MEMORANDUM

To: FILE
From: Jean Fraser
Subject: Application ID: 2014-033
Date: 4/11/2014

Comments Submitted by: Marge Schmuckal/Zoning on 4/10/2014

PICKUP WINDOW TO 25' SETBACK
MENU BOARD TO 25' SETBACK

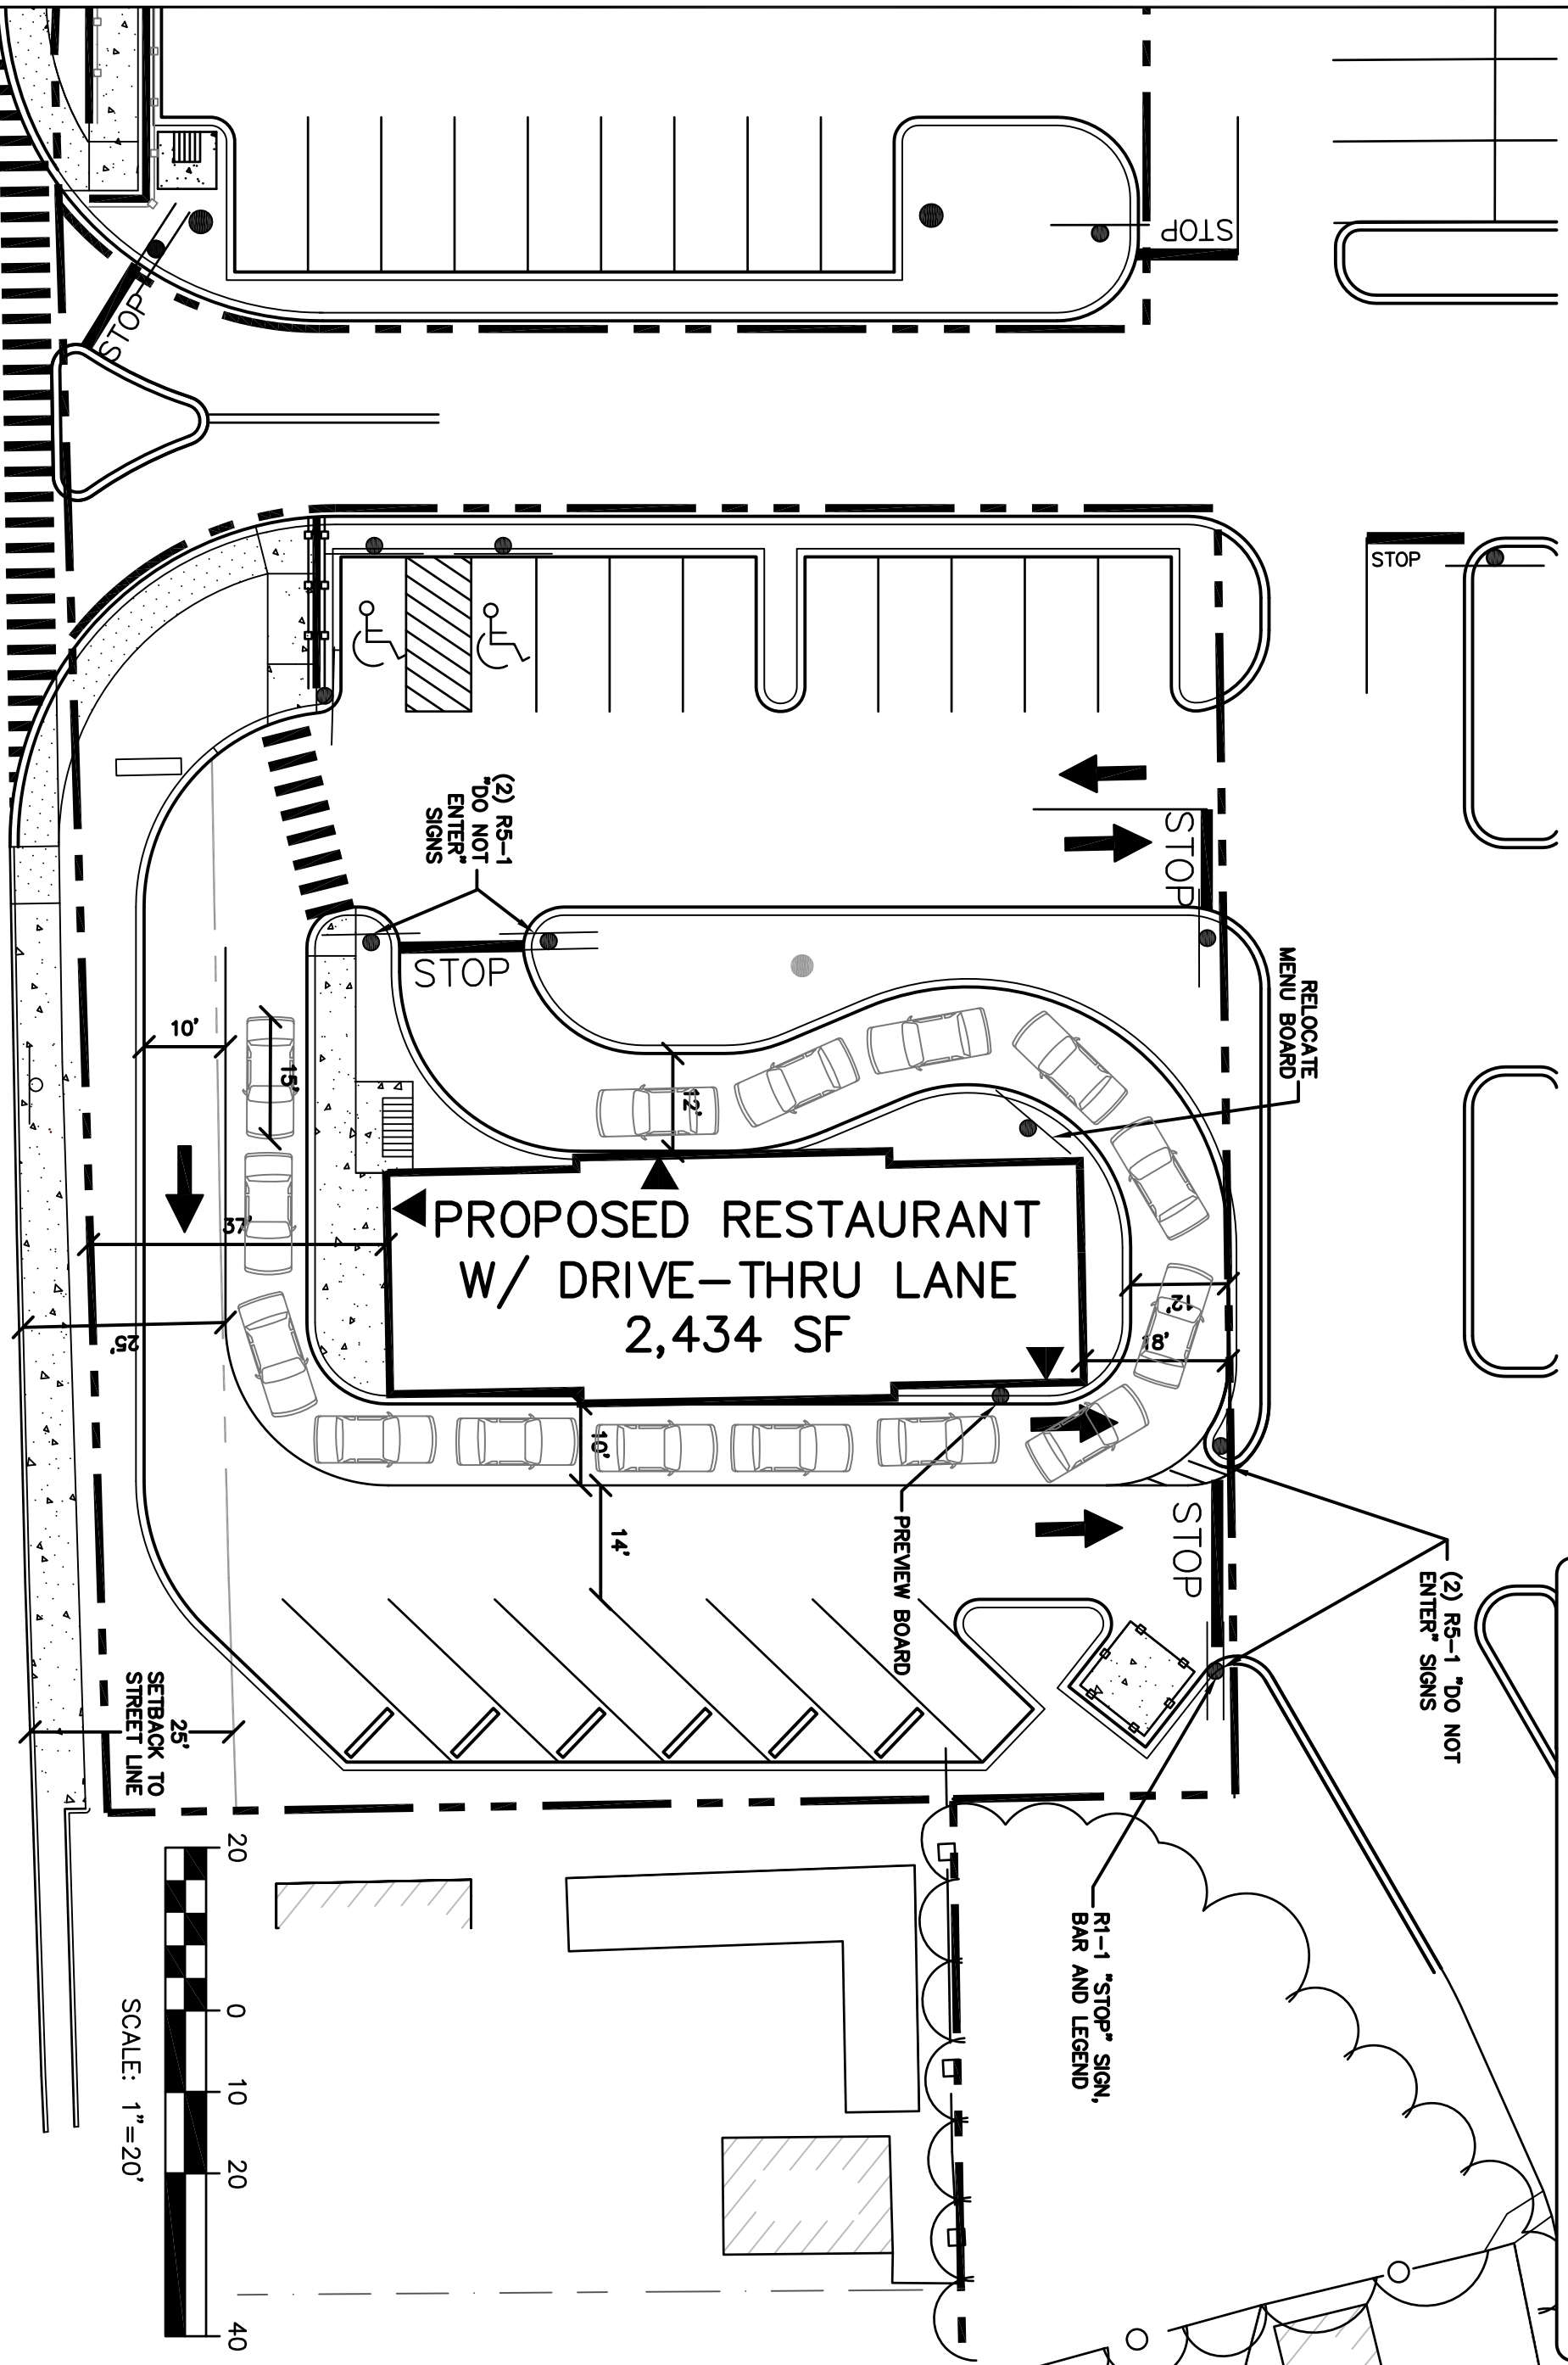
Section 14-183(a)6(a) specifically states within the text: "In addition, drive-through features shall not extend nearer than twenty-five (25) feet to the street line." There has been some concern as to where the measurement to the street line actually is located. The definition of "street line" is located in 14-47 and states: "Street line: the line of demarcation between a street and the abutting land." This definition does not use the terminology of abutting property line. Therefore I interpret the street line definition to mean the demarcation between the street pavement and the abutting land and not an abutting property line. The curb would be the specific transition point between the street and the abutting land.
